25 September 2017

**Submission: State Significant Infrastructure Application (SSI 6878) Yallah to Oak Flats
Princes Motorway Extension (Albion Park Rail Bypass) – Submission and Preferred
Infrastructure Report (SPIR)**

MACQUARIE RIVULET 20 YEAR ARI CHANGE IN WATER LEVEL - DRAFT 2016 FLOOD MODEL

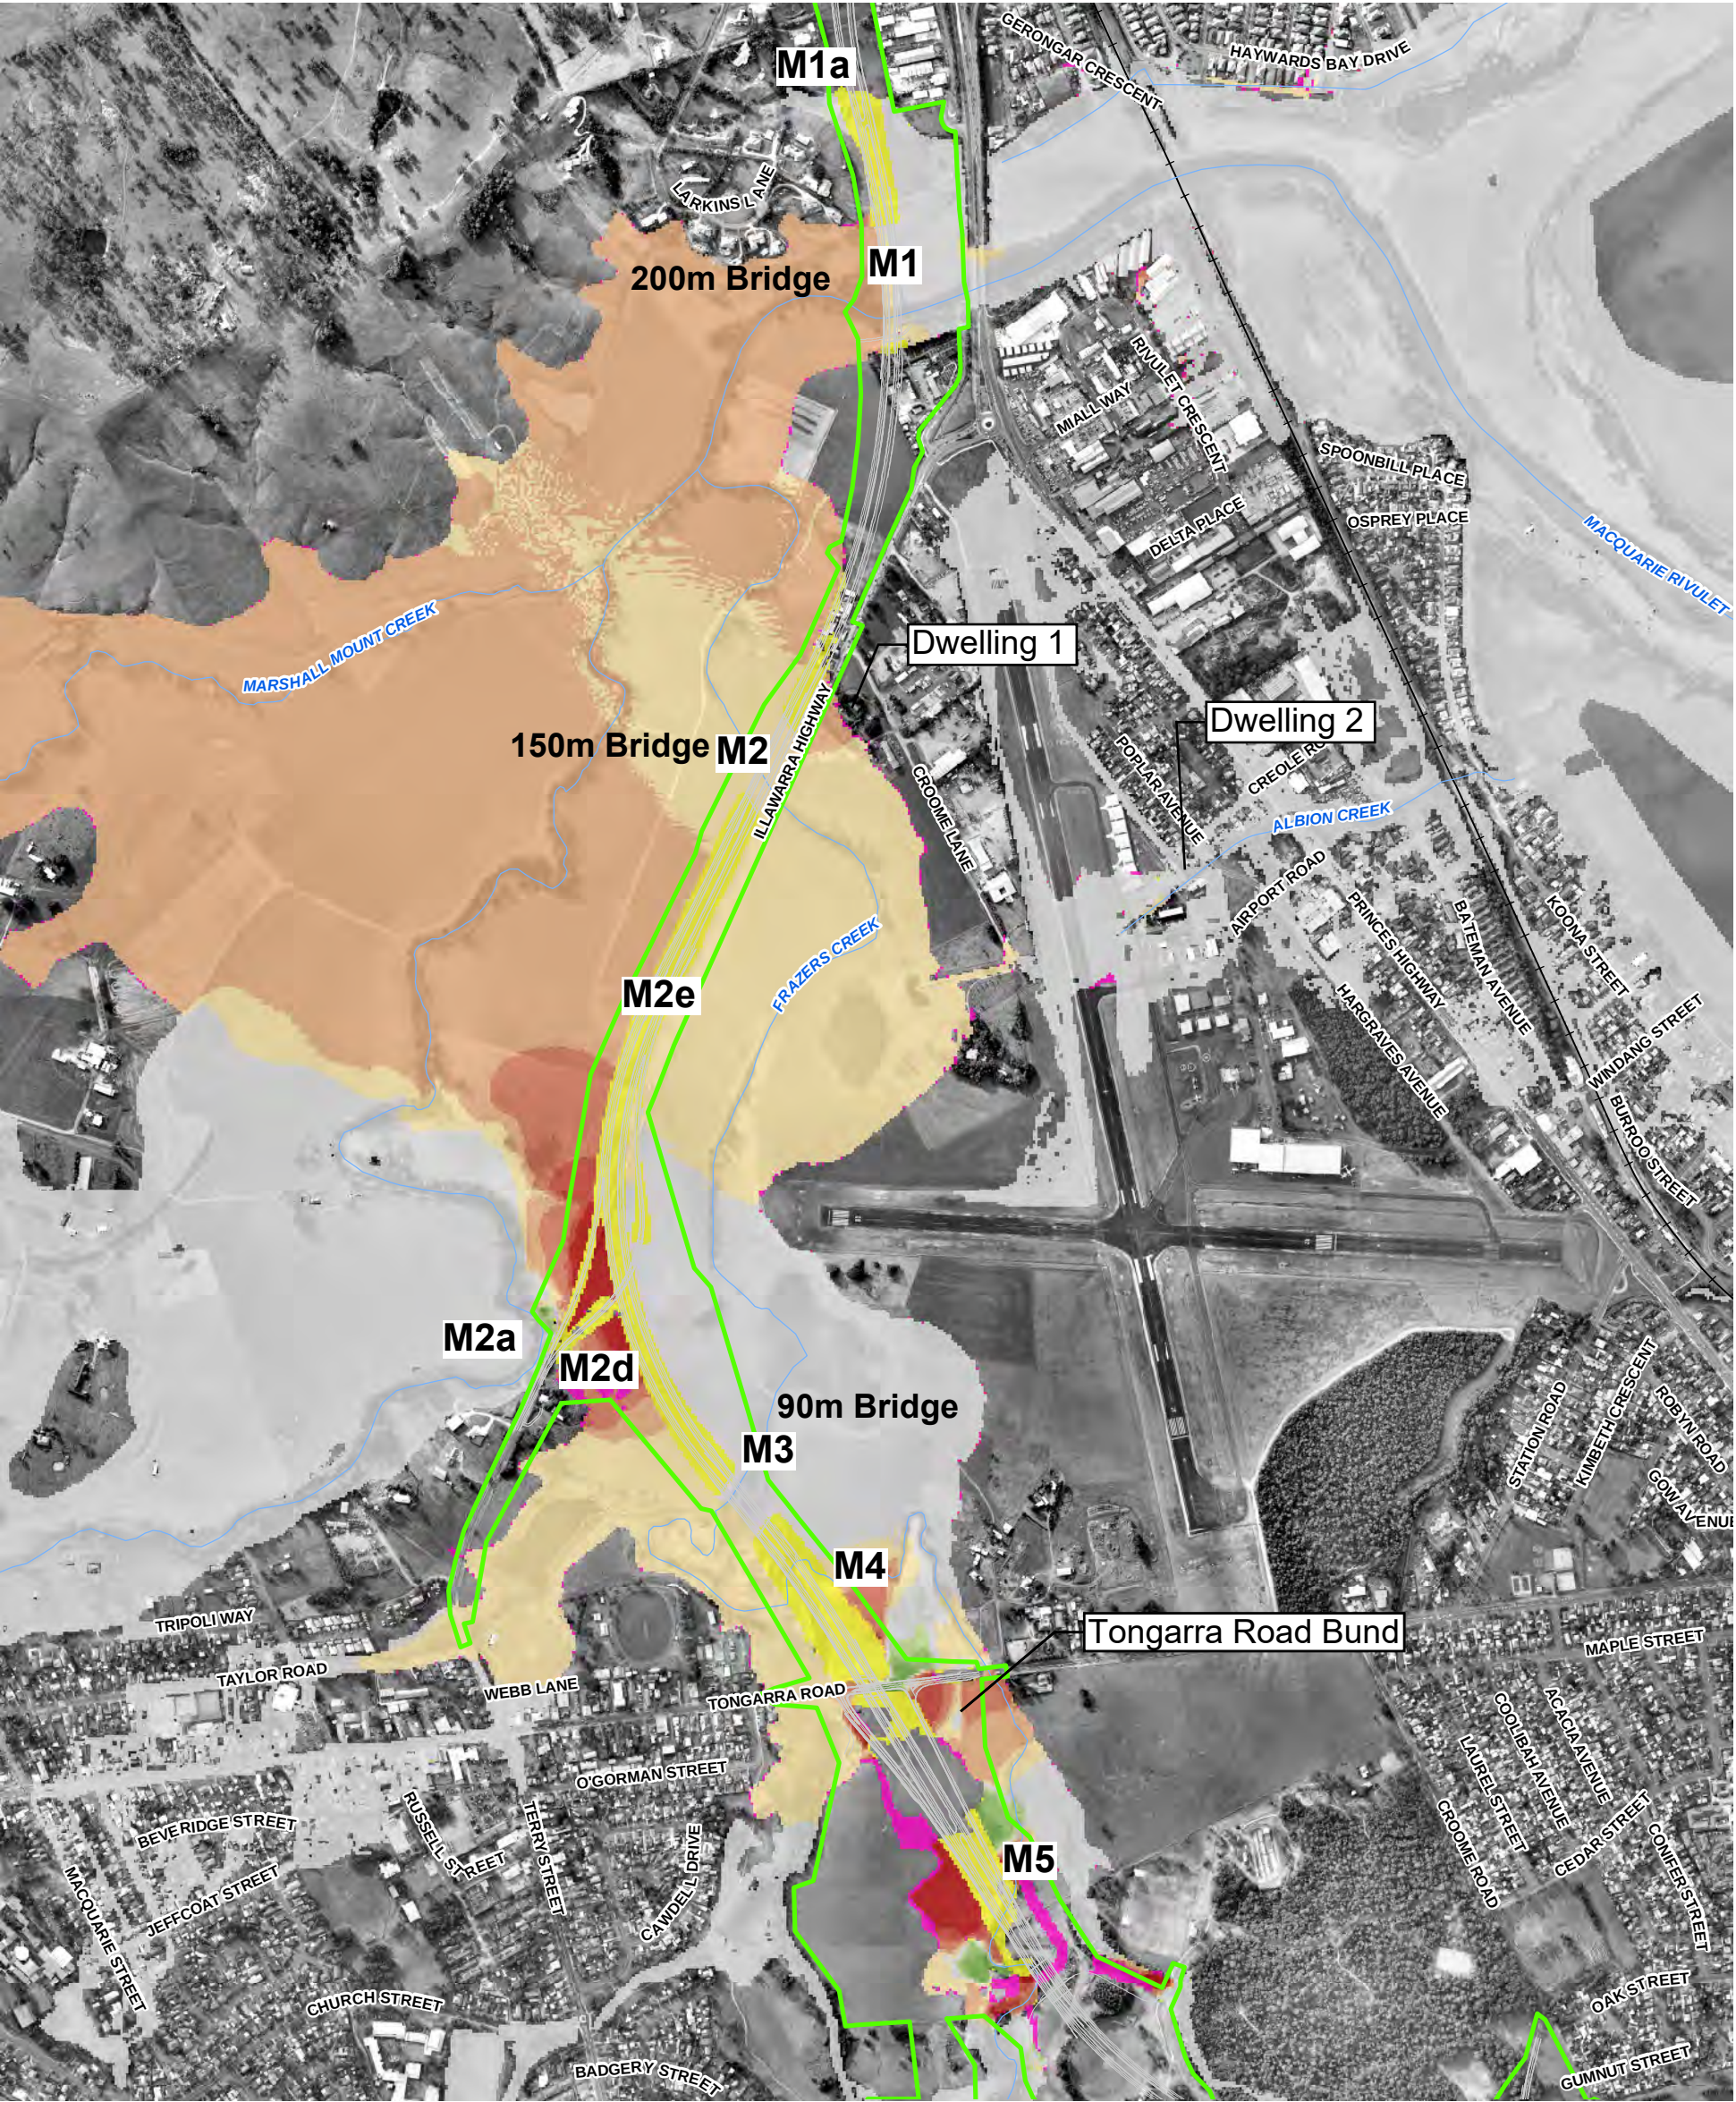
- Although flood impacts at the Taylor Road/Illawarra Hwy intersection are shown to be negligible in the larger (50yr, 100yr, 200yr) events, there are still significant impacts in the 10 year and 20 year event at this location. It is unclear whether RMS intend on managing these impacts as part of the project.

- Further investigation of flood mitigation options at the general location of Taylor Road and the Illawarra Highway is required to further limit the impact of the project in the 10 year and 20 year flood events. If impacts cannot be mitigated through adjustments to the design of the project, other mitigation measures offsite to the project must be implemented to manage the impacts.

Figure 6-12 Albion Park Interchange

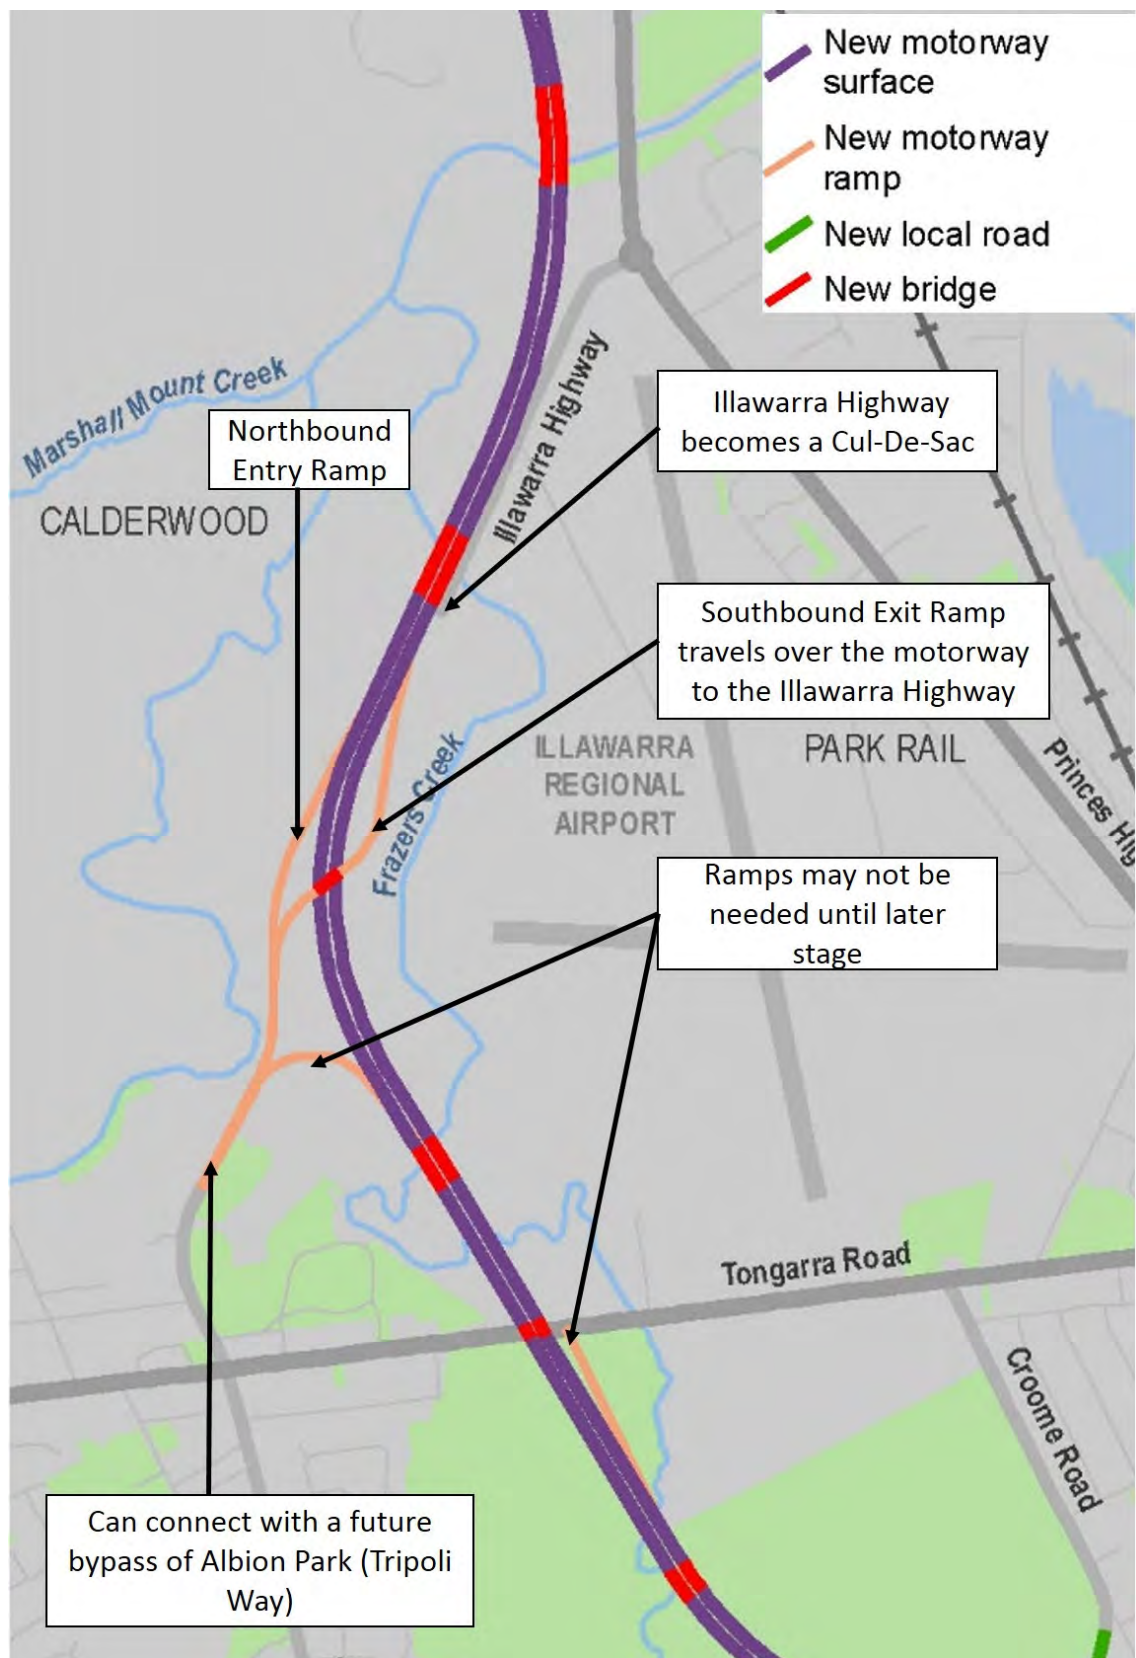
It is interesting to note that the EIS option (refer Figure 5-23 Interchange at Albion Park – Construction) had the northbound off ramp merging into a single lane on the Illawarra Highway

without a weave conflict. In this regard the claim that the Design Refinement addresses a road safety issue is incorrect.
